Department of Planning and Environment
4 Parramatta Square, 12 Darcy Street
Parramatta NSW 2124

Your Ref	SSD-71558711
Our Ref	NCA/6/2024
Contact	Douglas Bennett
Telephone	02 9806 5405
Email	dbennett@cityofparramatta.nsw.gov.au

COUNCIL SUBMISSION TO REQUEST FOR ADVICE ON EIS – MIXED-USE PRECINCT WITH IN-FILL AFFORDABLE HOUSING – HUGHES AVENUE, MELROSE PARK SOUTH-WEST

OS4-L-401

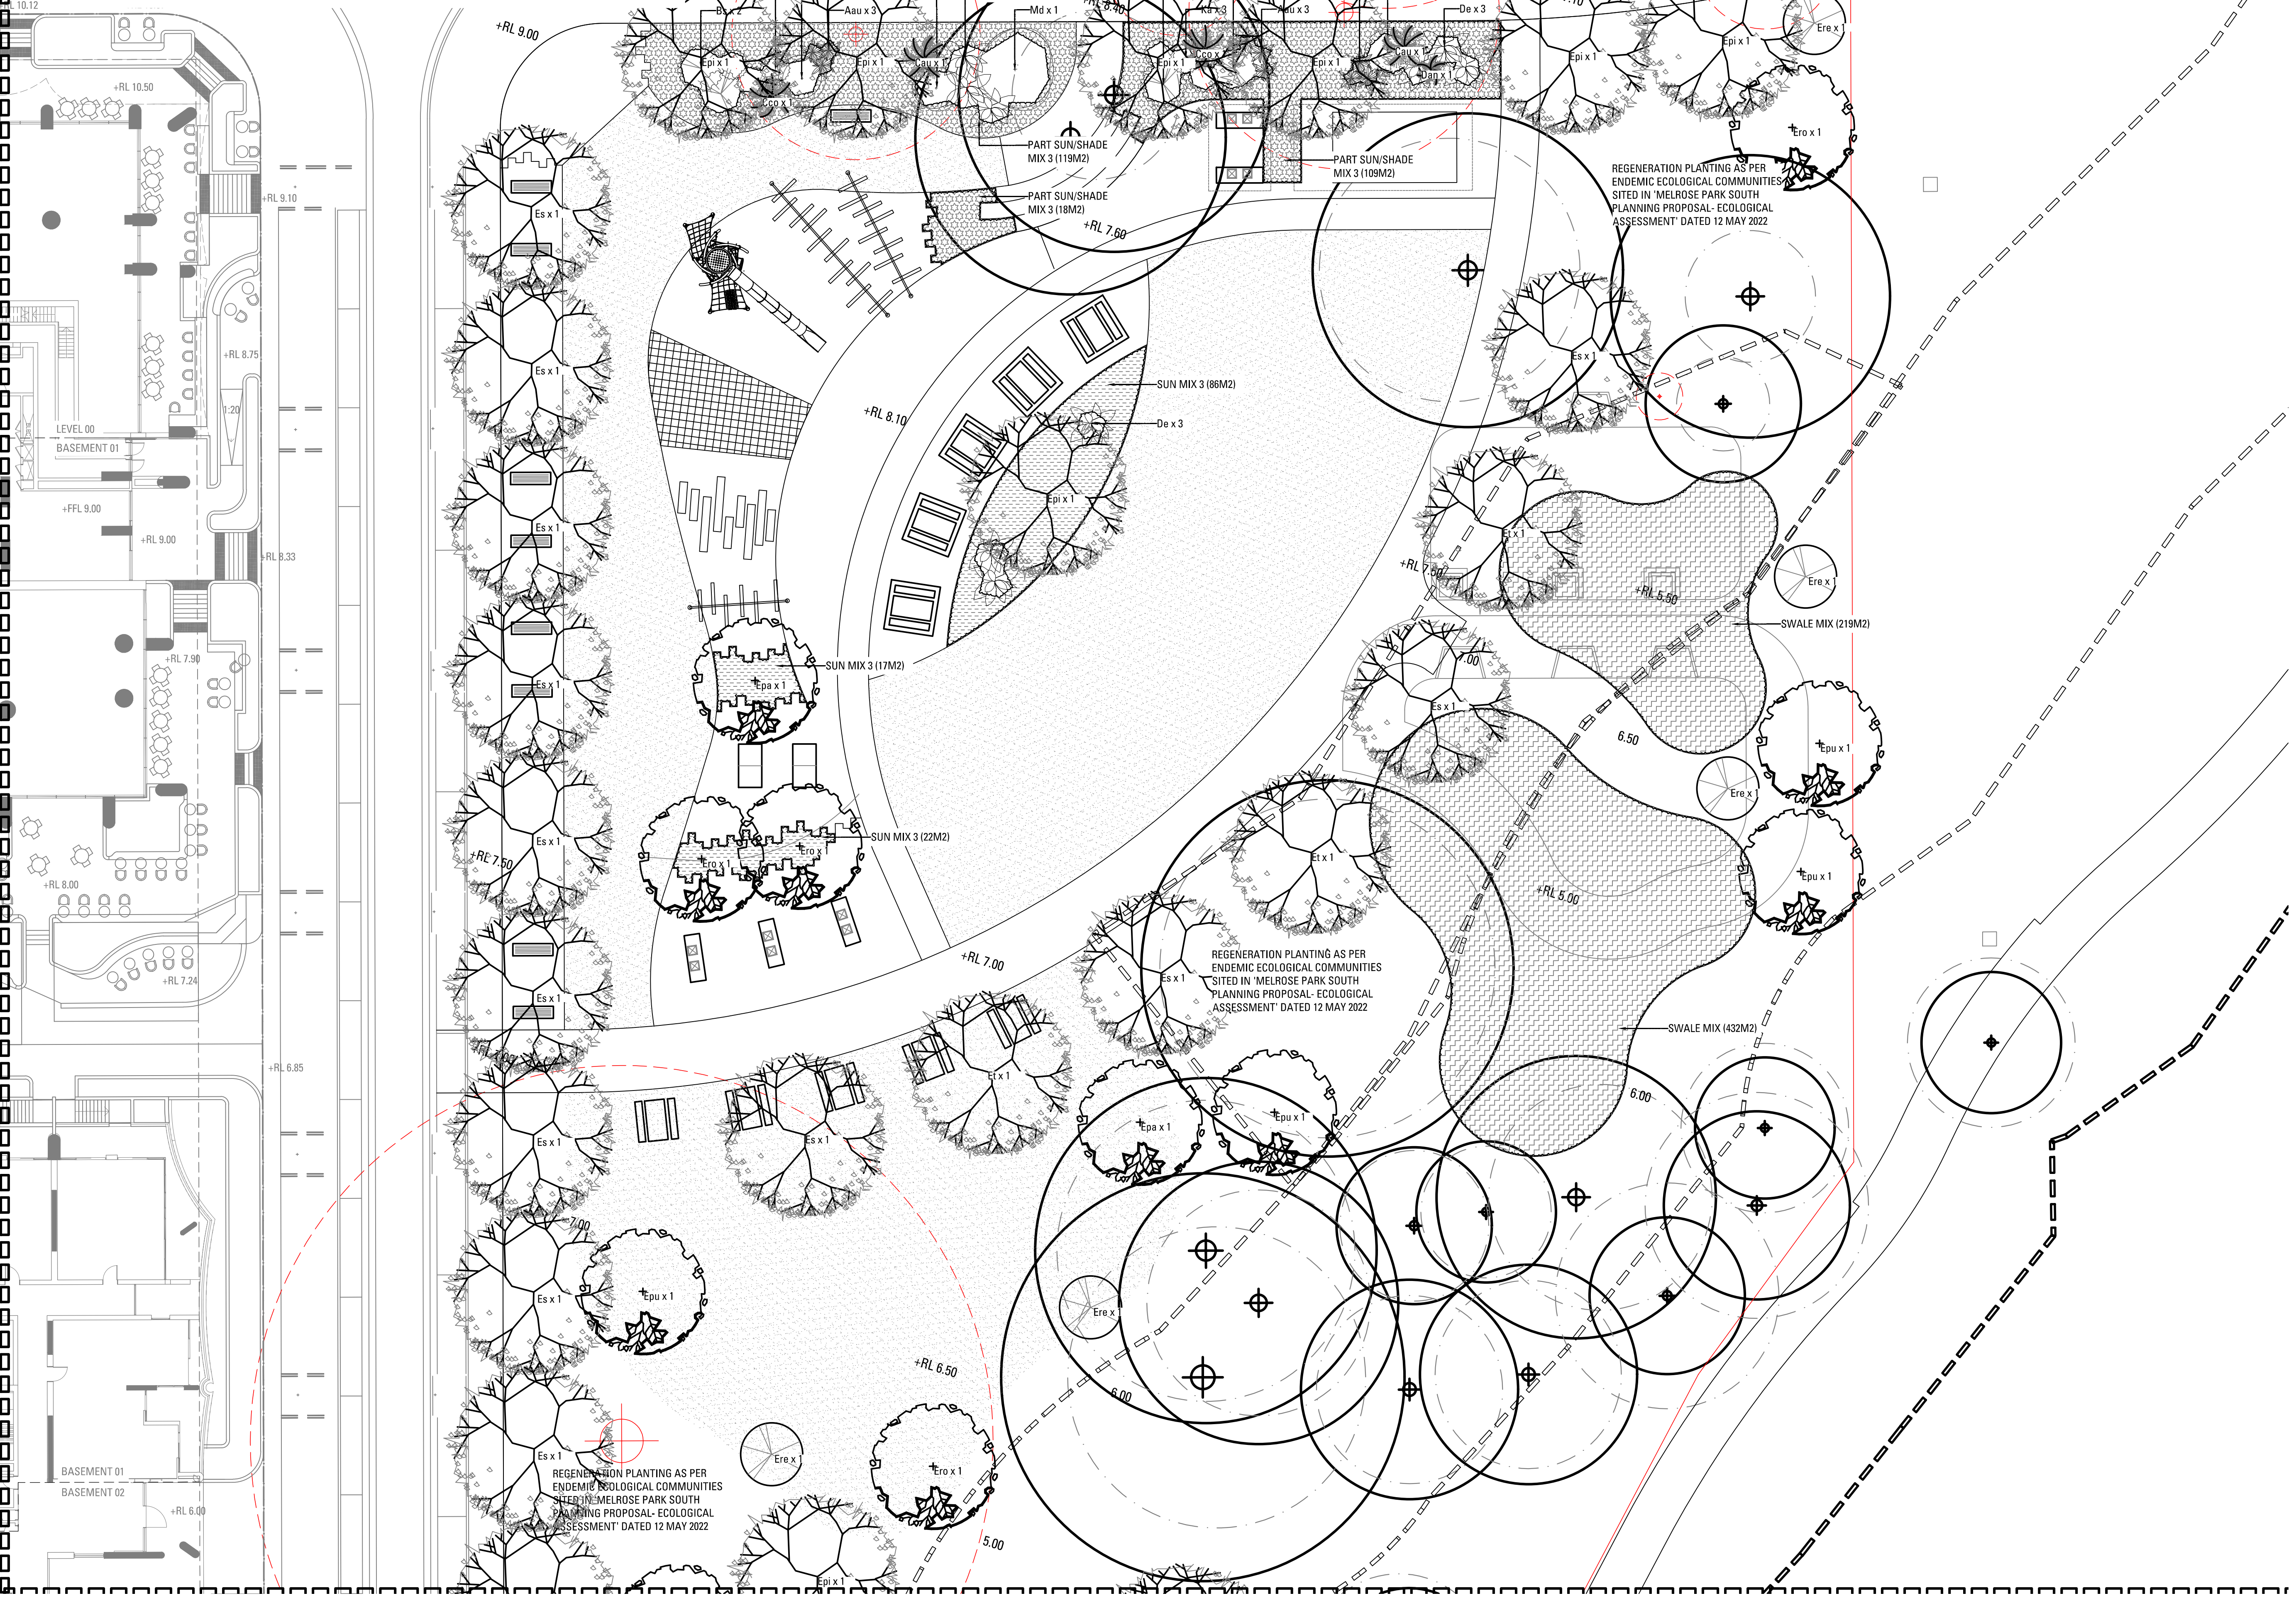
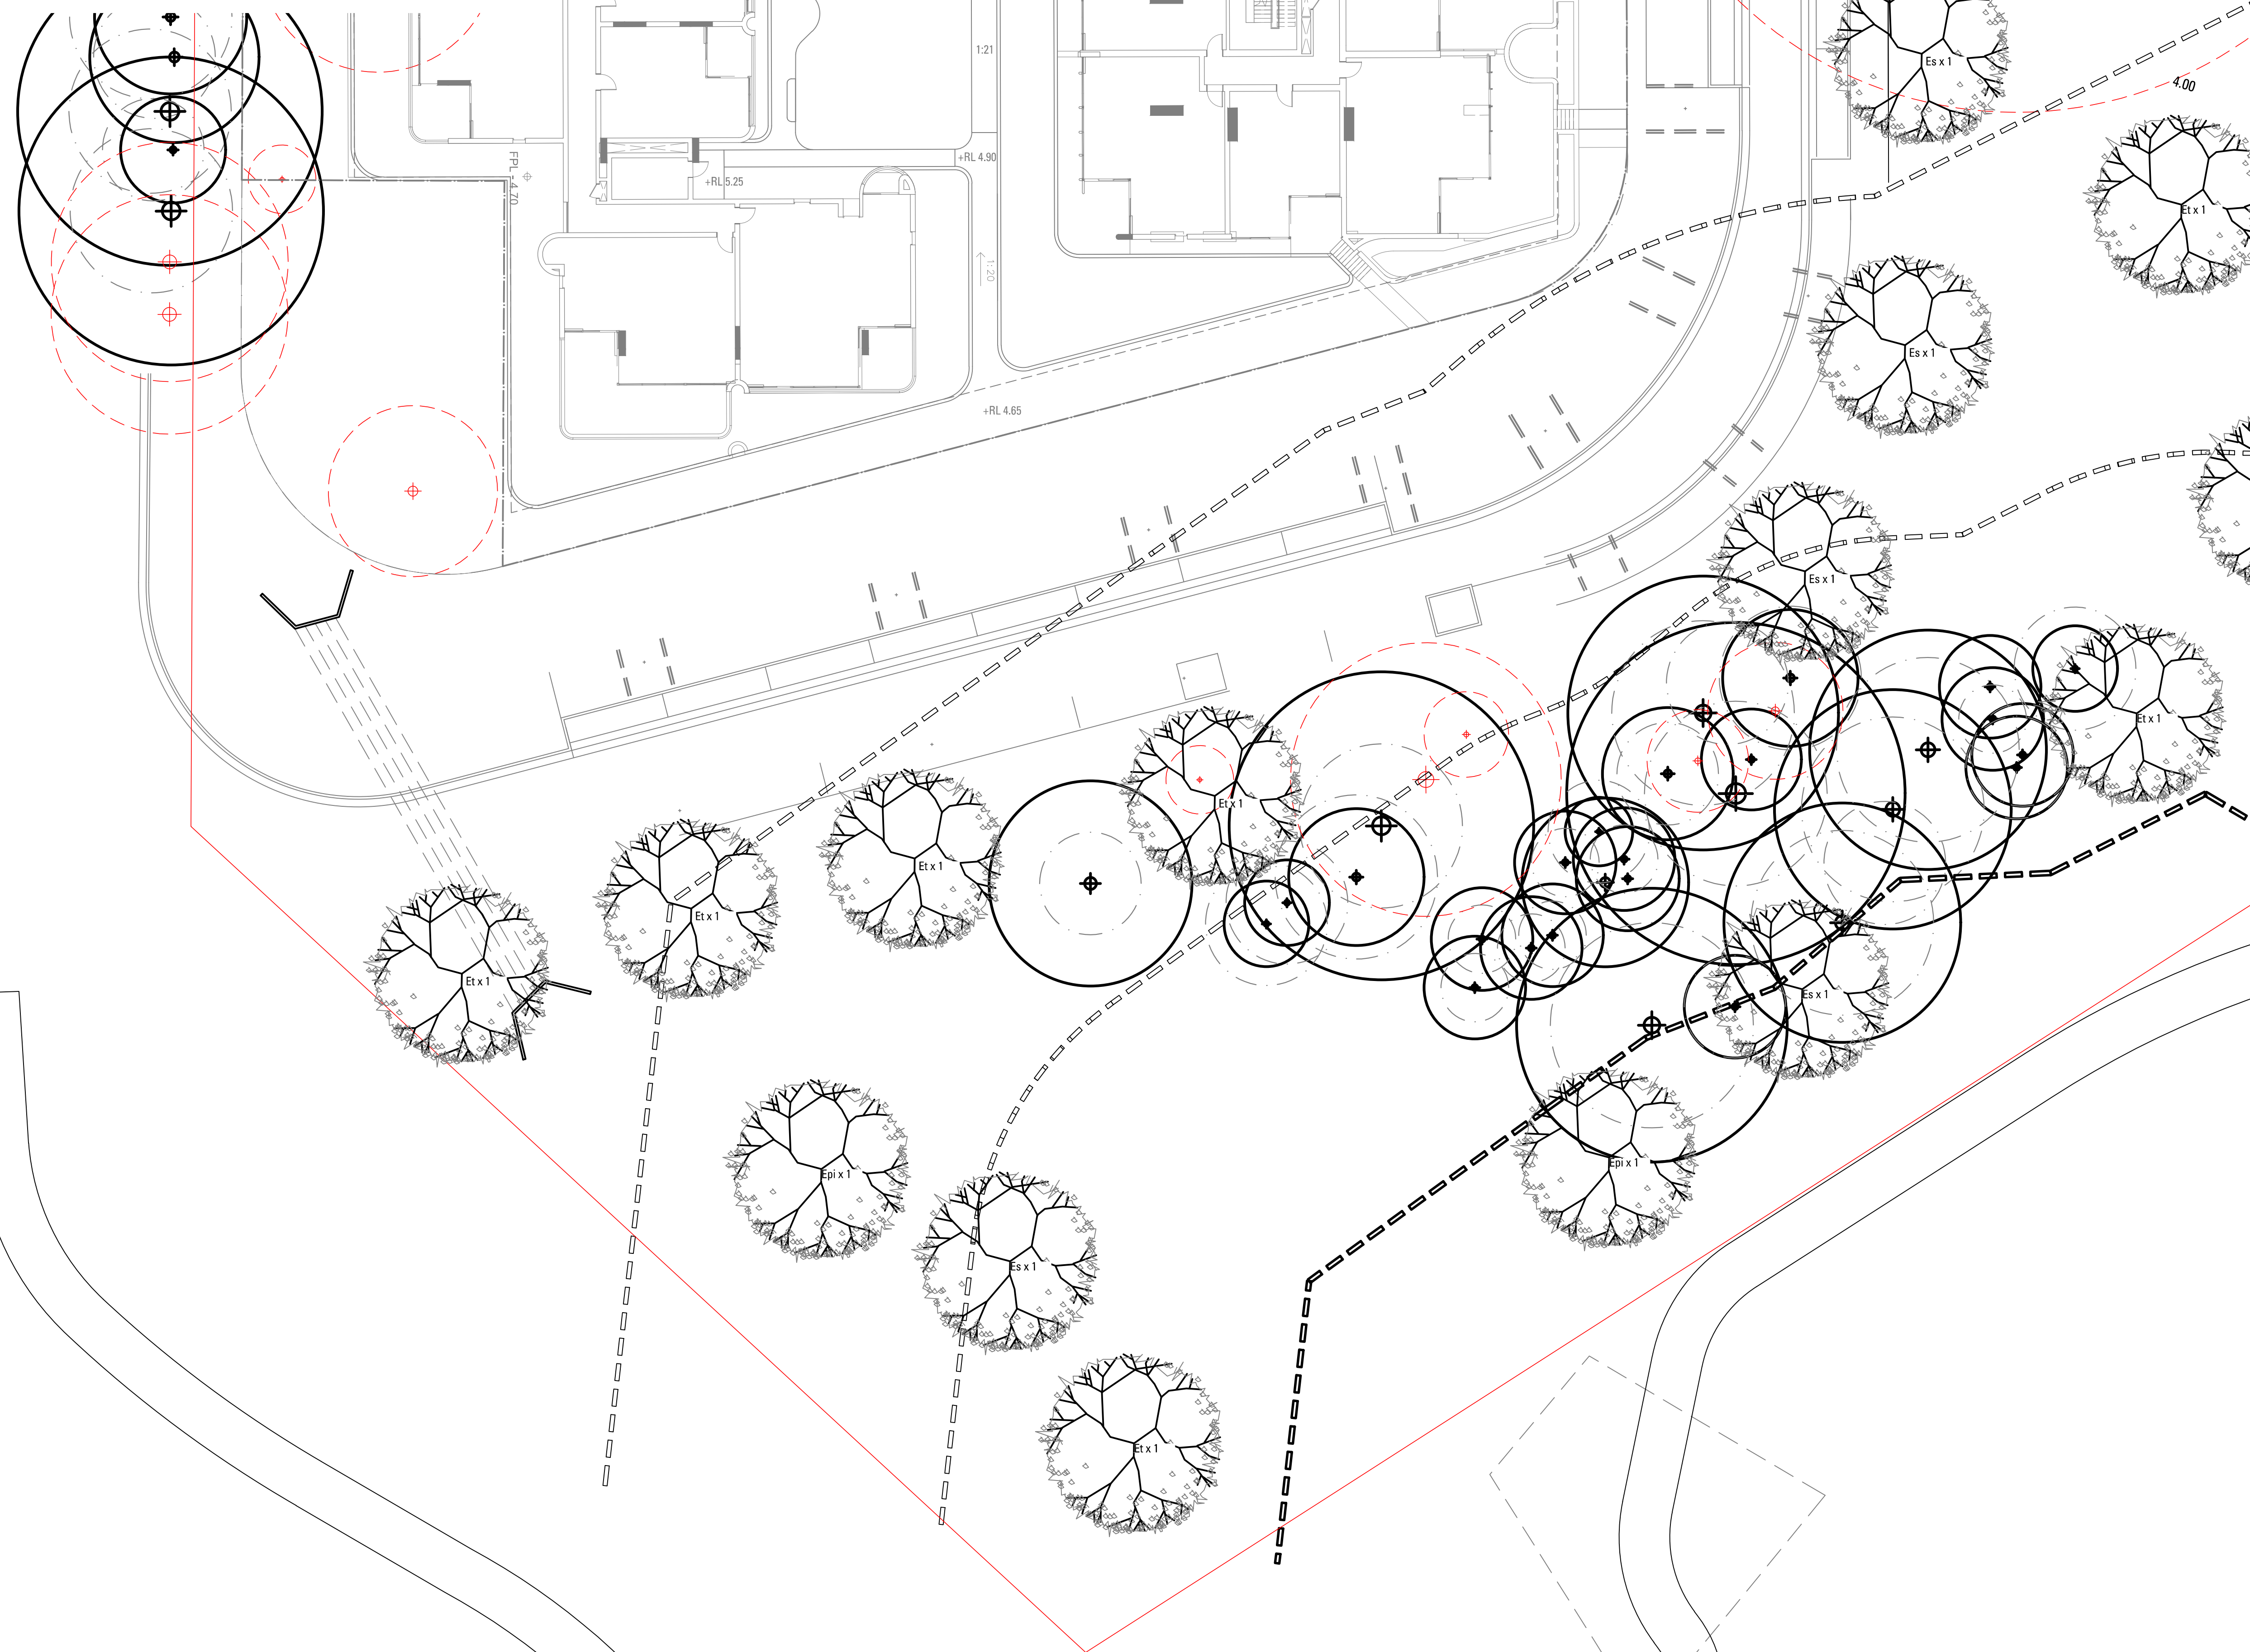
Council requests that *Pennisetum sp.* be replaced with *Poa labillardieri* and/or *Poa poiformis* as *Pennisetum* is an undesirable species in this location.

Maximum grades of 1:5 (Turf) and 1:3 (Garden beds) should be provided (and confirmed by showing levels on plans) to facilitate safe maintenance access. In addition, turf zones require minimum 2m clearances to pathway edges for mower access.

Riparian planting palette should comprise species from endemic ecological communities (Sydney Coastal Sandstone Foreshores Forest / Sydney Enriched Sandstone Moist Forest / River Mangrove Forest / Coastal Saltmarsh) to enhance ecological integrity.
